CITY OF ALBUQUERQUE

**Re: Holly Estates Subdivision
Erosion and Sediment Control Plan
Engineer's Stamp Date 8-27-16 (C21E040)**

Holly Estates Subdivision

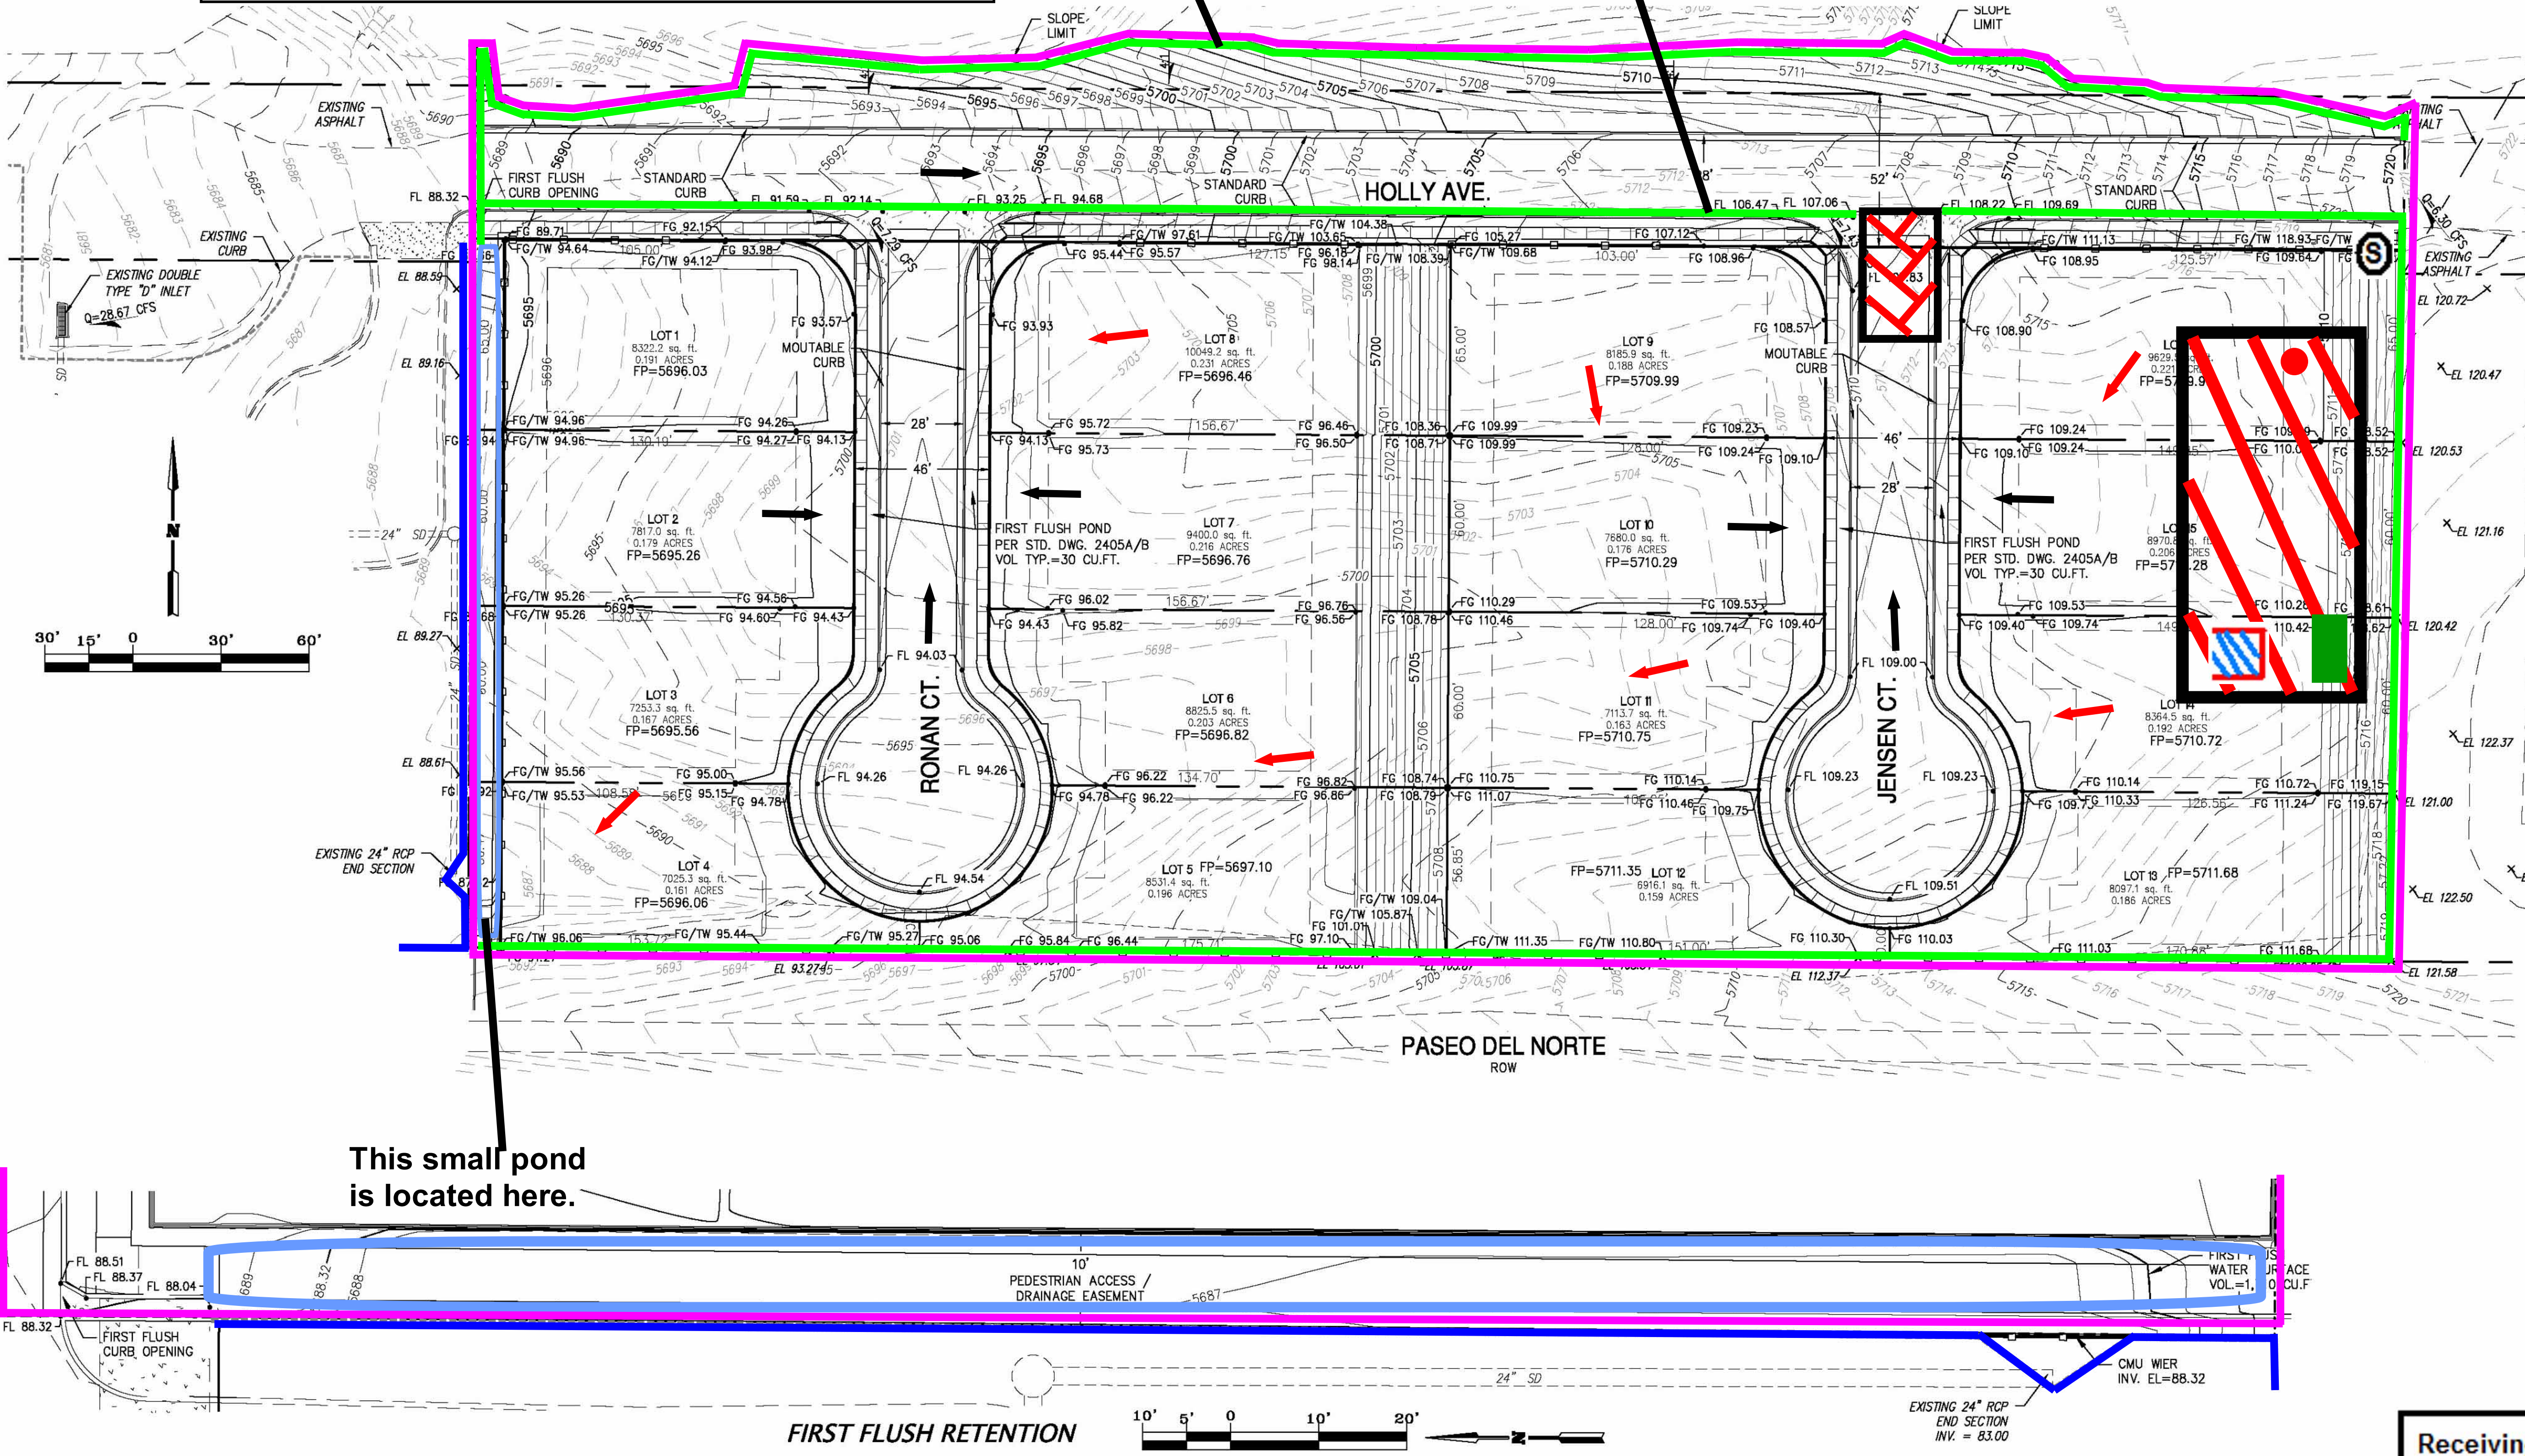
Provide inlet protection, that does not cover the grate (e.g. wattle/mulch sock), for the inlet located in the cul-de-sac.
